Non-Material Amendment Application to planning permission 3/2022/0537: Land adjacent to Northcote Road, Langho BB6 8BG

On behalf of our client Alderley Group, please find enclosed an application for a Non-Material Amendment in respect of the above planning permission, submitted under Section 96A of the Town and Country Planning Act 1990 (as amended) (PP-13778867).

Summary of the Proposed Changes

Drawing Title
BOUNDARY TREATMENT DETAILS

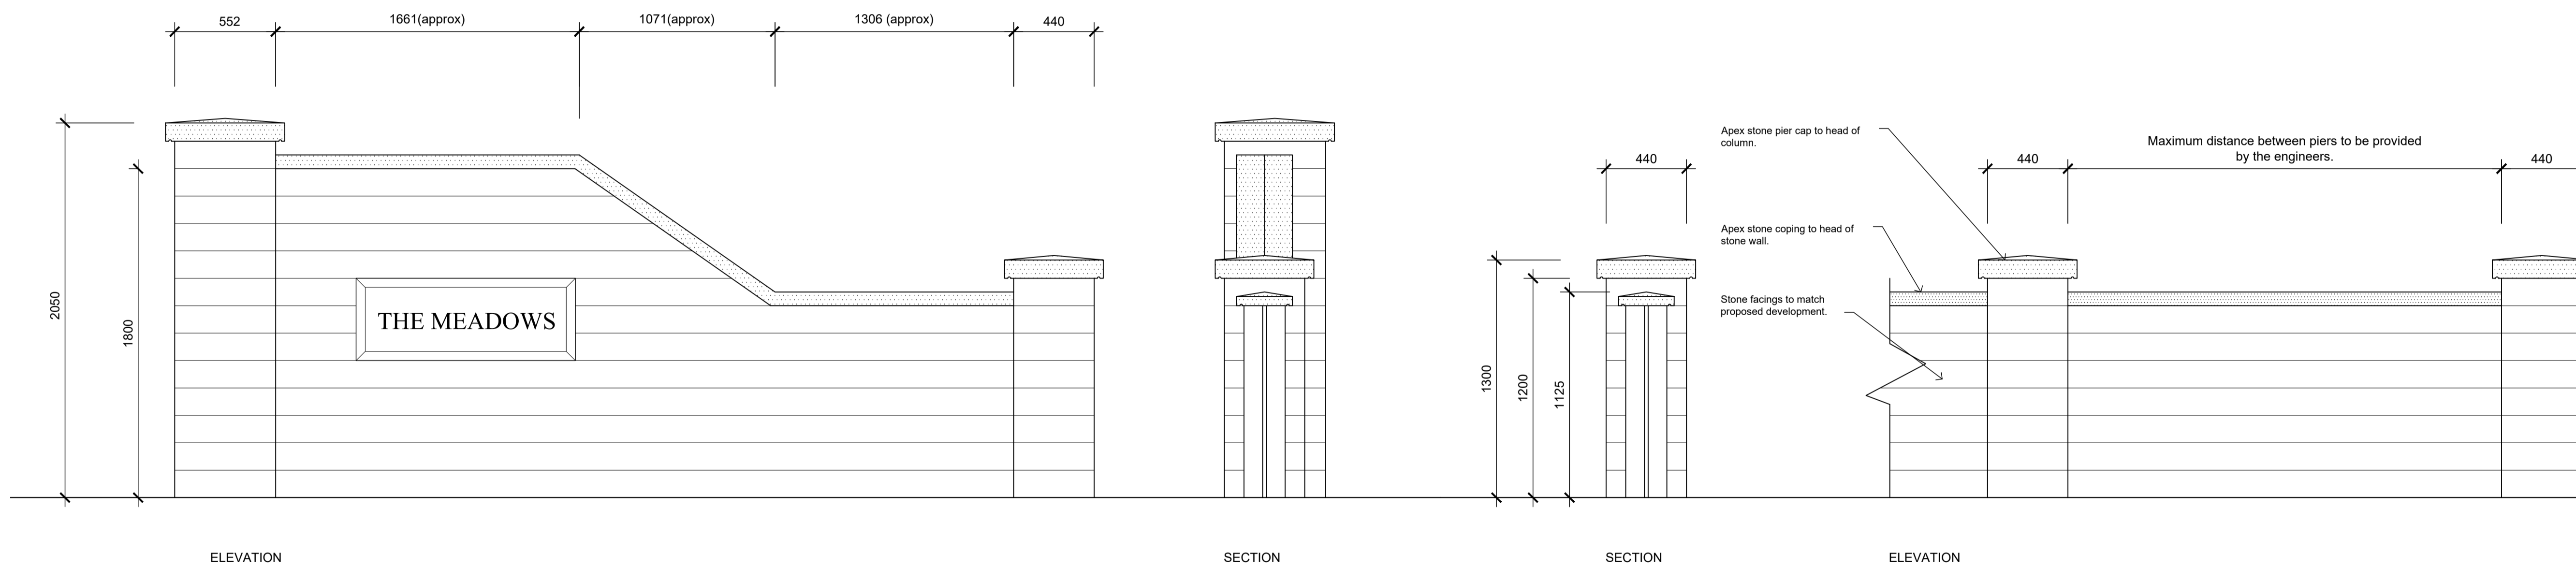
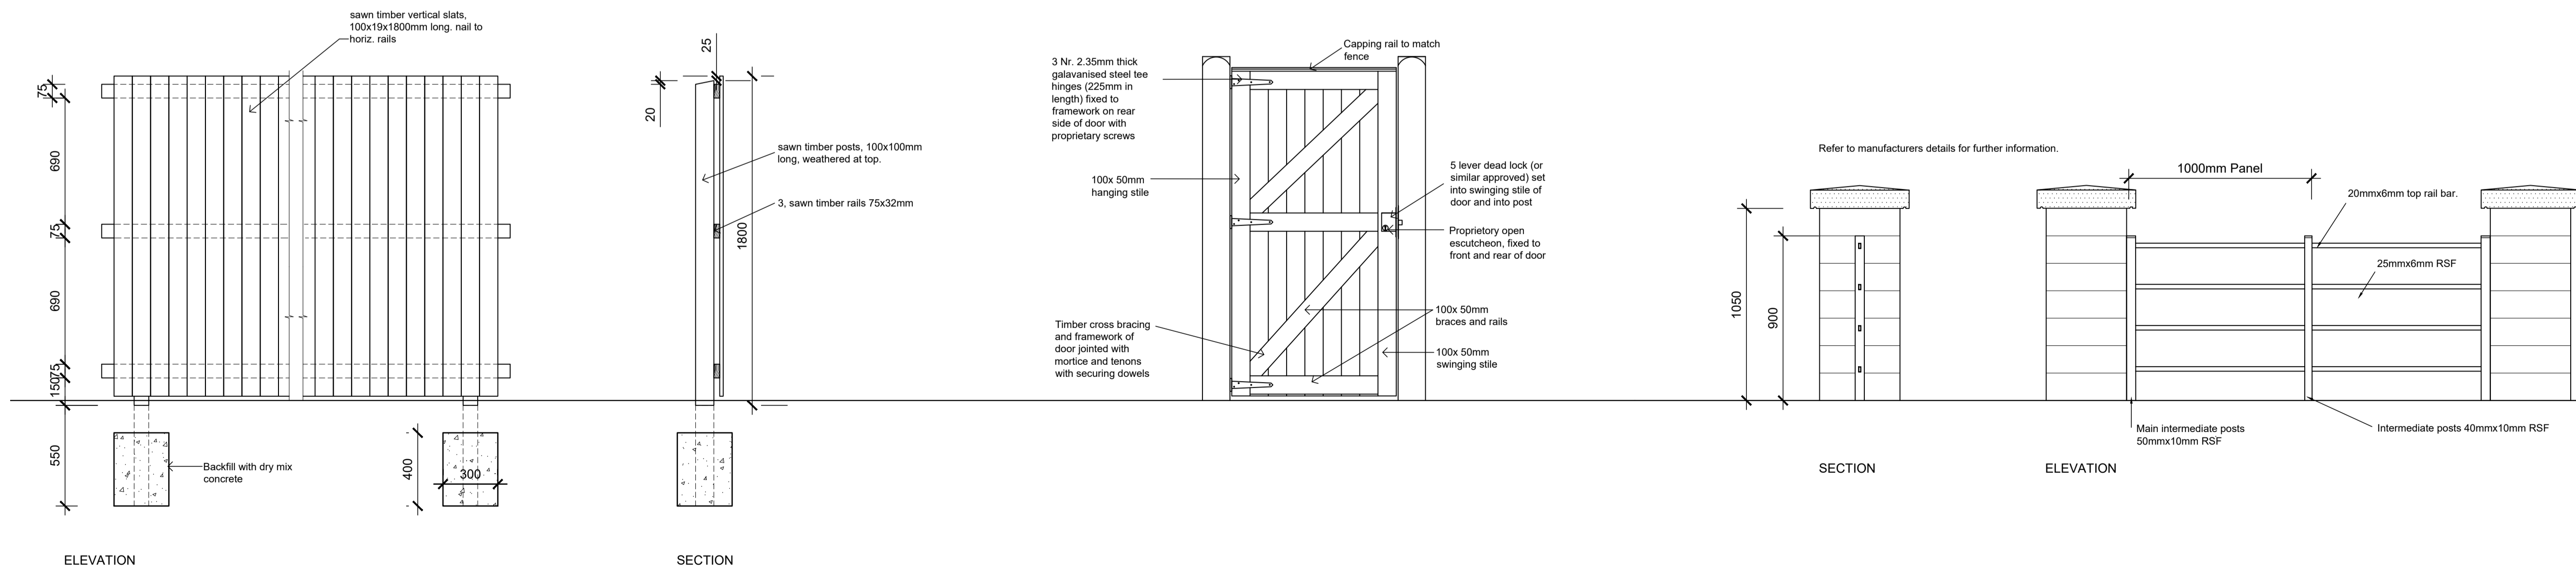
- Slight repositioning of the Plot 2 driveway.
- Lowering the pitch of the garage roof to Plot 7, which results in a reduction in its height by 400mm.
- Adjusting the rear dormers to Plot 8 to incorporate a flat roof design, to accommodate the required number of PV panels on the wider roof.
- Addition of PV panels to the houses.
- Introduction of flat-roofed portico features to front entrances in place of consented door canopies.
- Minor adjustment to consented chimney positions.
- Updates to the consented material schedule for the houses.
- Introduction of a hard verge to the west of the access road to assist with the construction of a retaining landscape batter to manage the levels difference.
- Updated feature wall – ‘The Meadows’ - added to the side of the main entrance into the development.
